Ref: Planning Application: FG/159/18/PL Bluebird Cafe

On behalf of Kingston Gorse Estate Board, I make the following comments on the planning application relating to the Bluebird Café. Please accept this letter as an objection to the planning application.

01 PROPOSED NORTH ELEVATION  
2003 Scale: 1:100

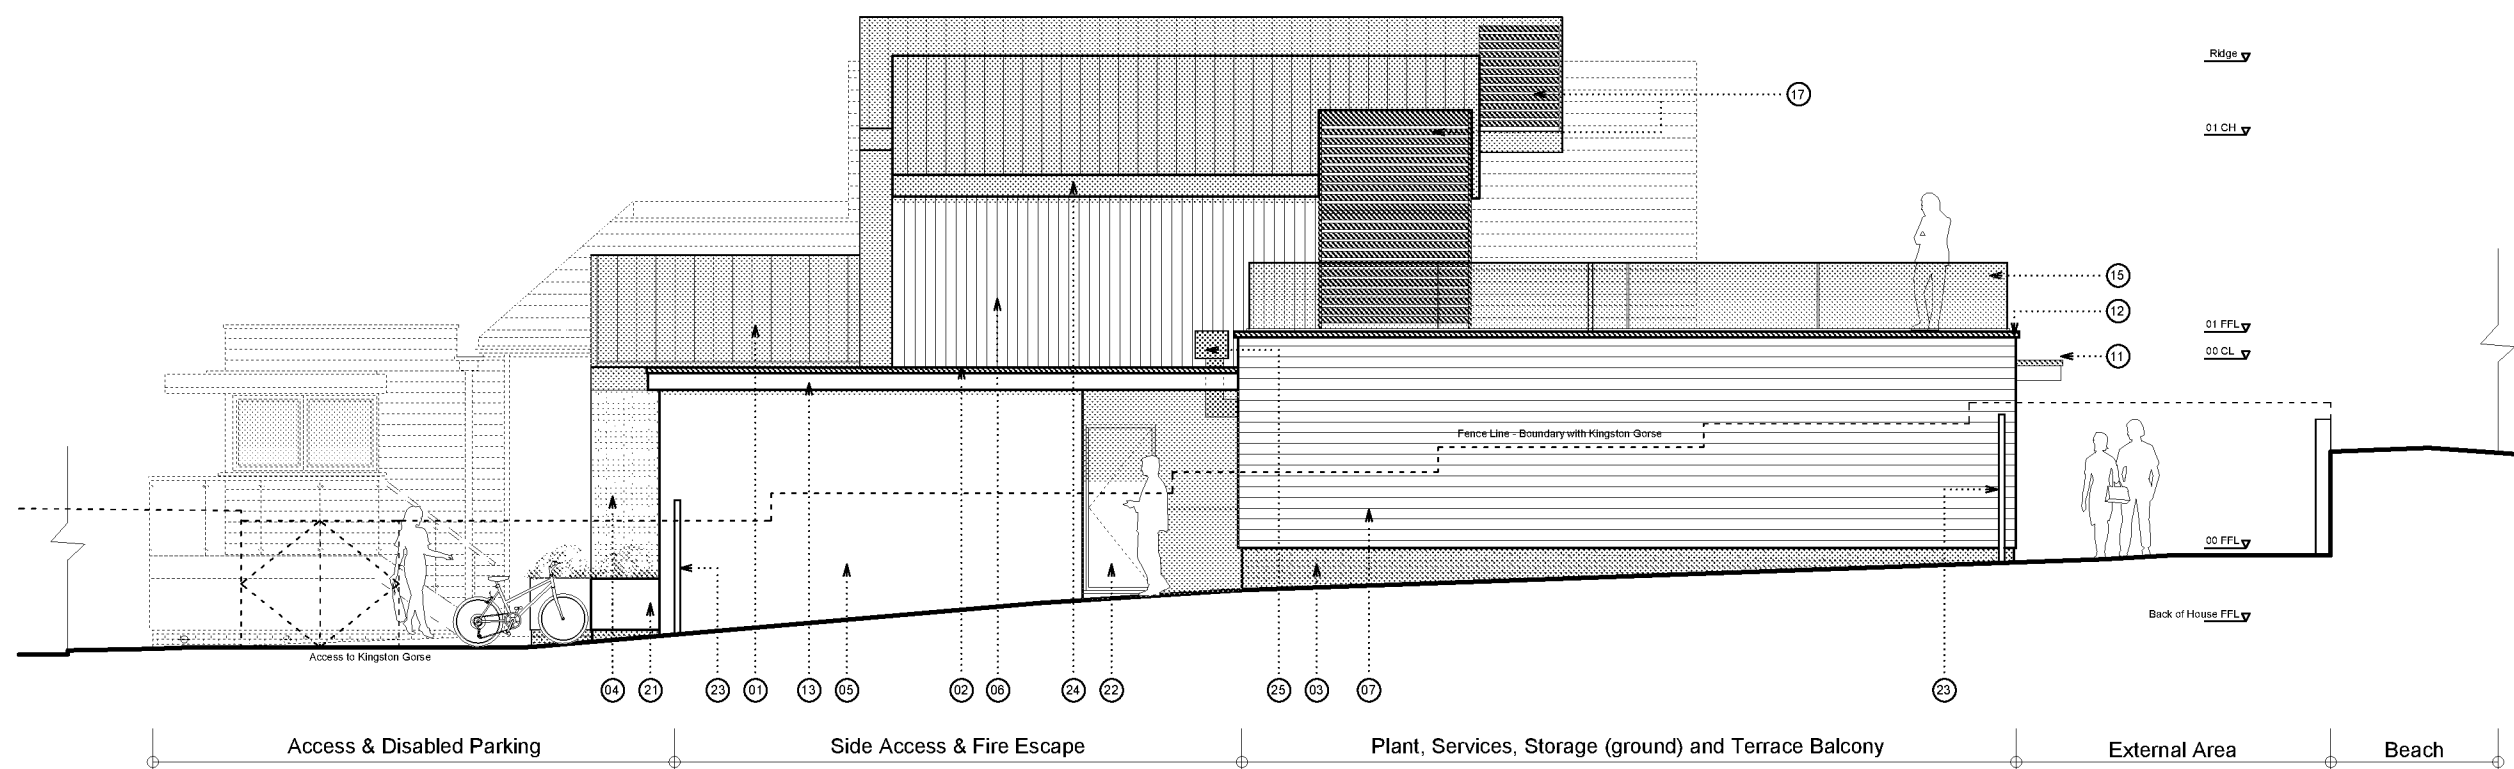
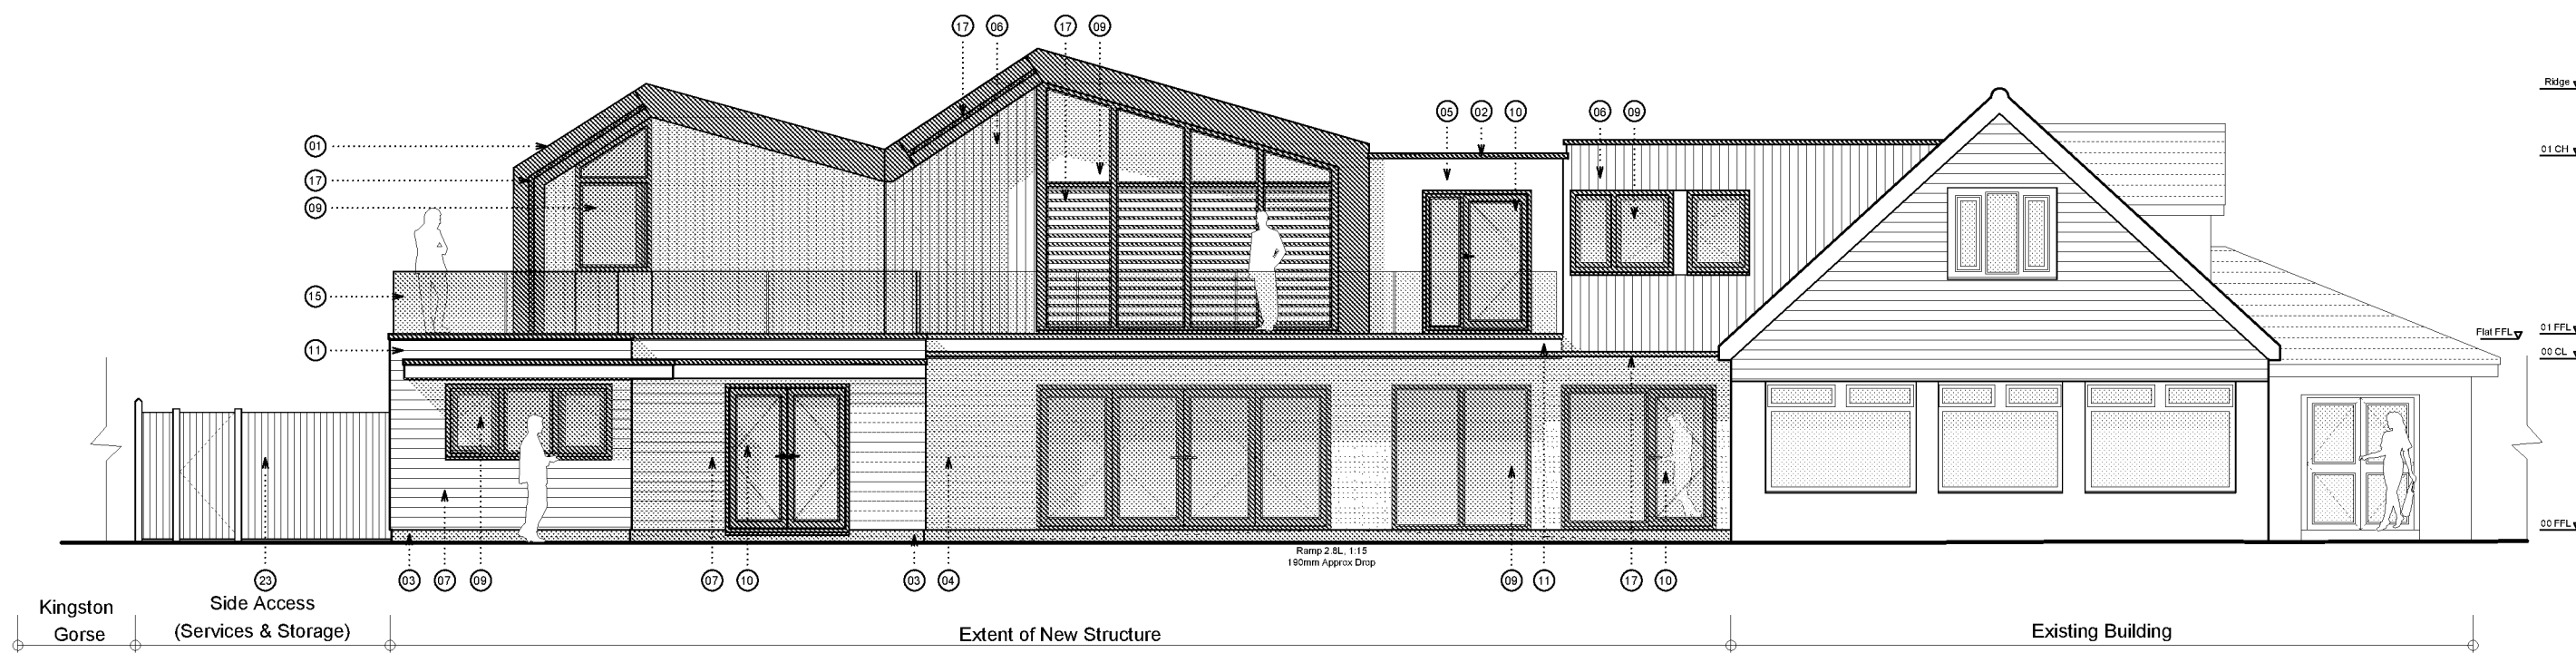
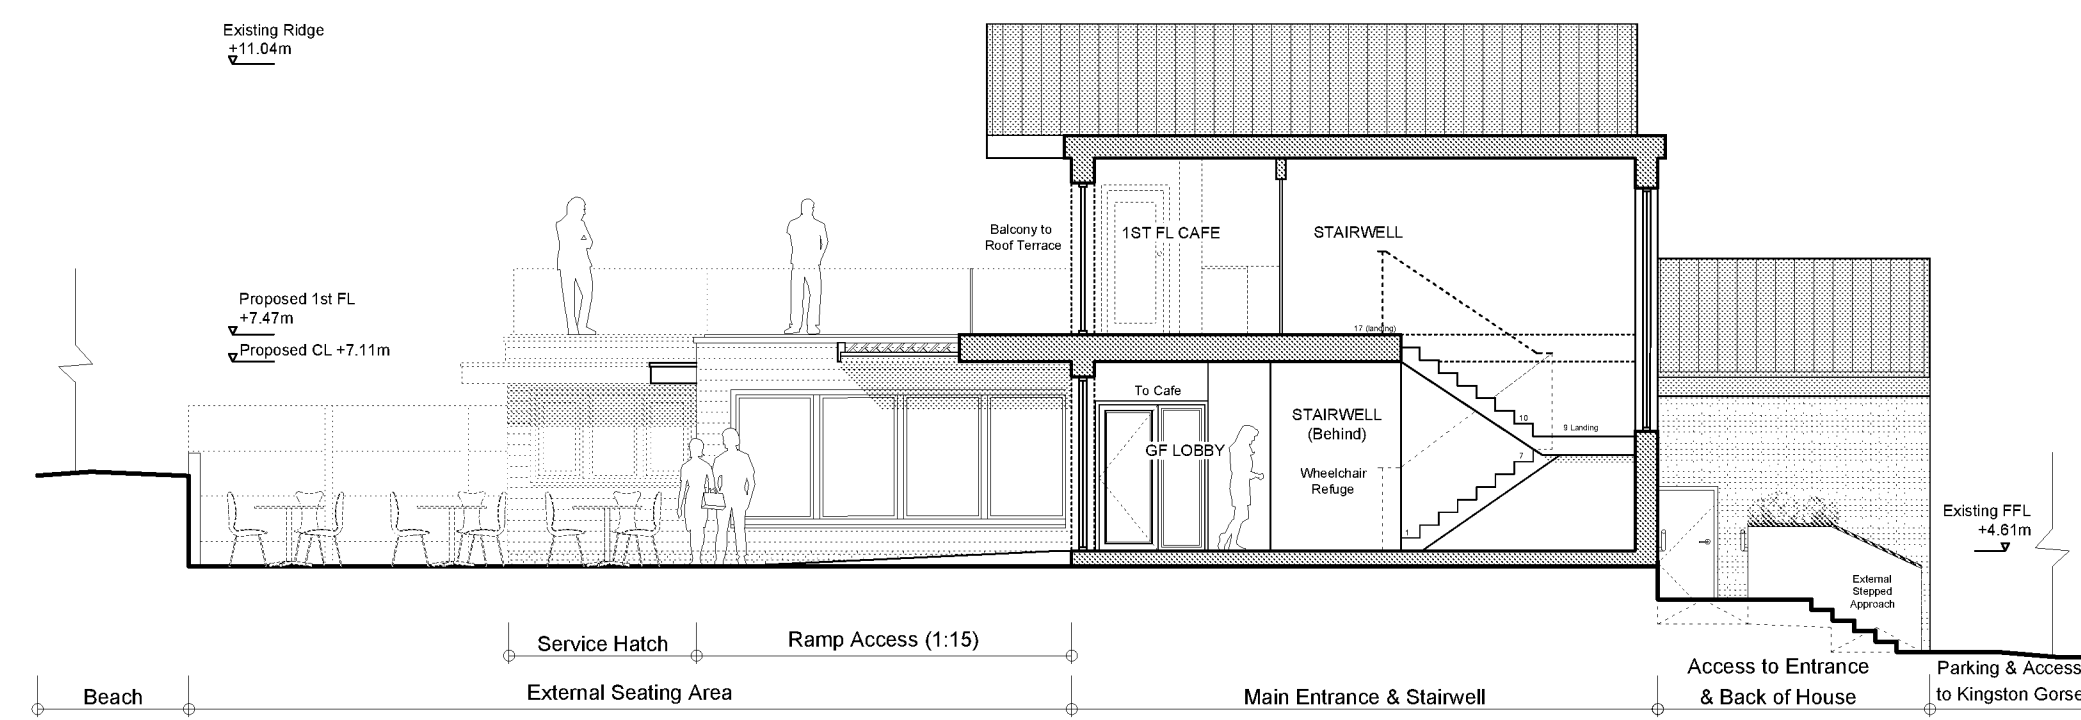
- a) Overlooking: The first-floor balconies in the new development will overlook the properties to the west.*
- b) Privacy: The windows and balconies facing west will cause a loss of privacy to adjacent properties.*
- c) View: As the proposed building is significantly south of the existing properties it will be of detriment to views afforded to adjacent properties on Kingston Gorse thereby having an adverse effect on the residential amenity.*
- d) The new development will attract a greater number of visitors significantly increasing traffic movement in an area that has insufficient access and parking facilities.*
- e) Increased noise from customers/music particularly during the extended evening periods will impact on neighbouring properties.*
- f) Increased traffic noise, particularly in evening, due to a greater number of car movements in the car park.*
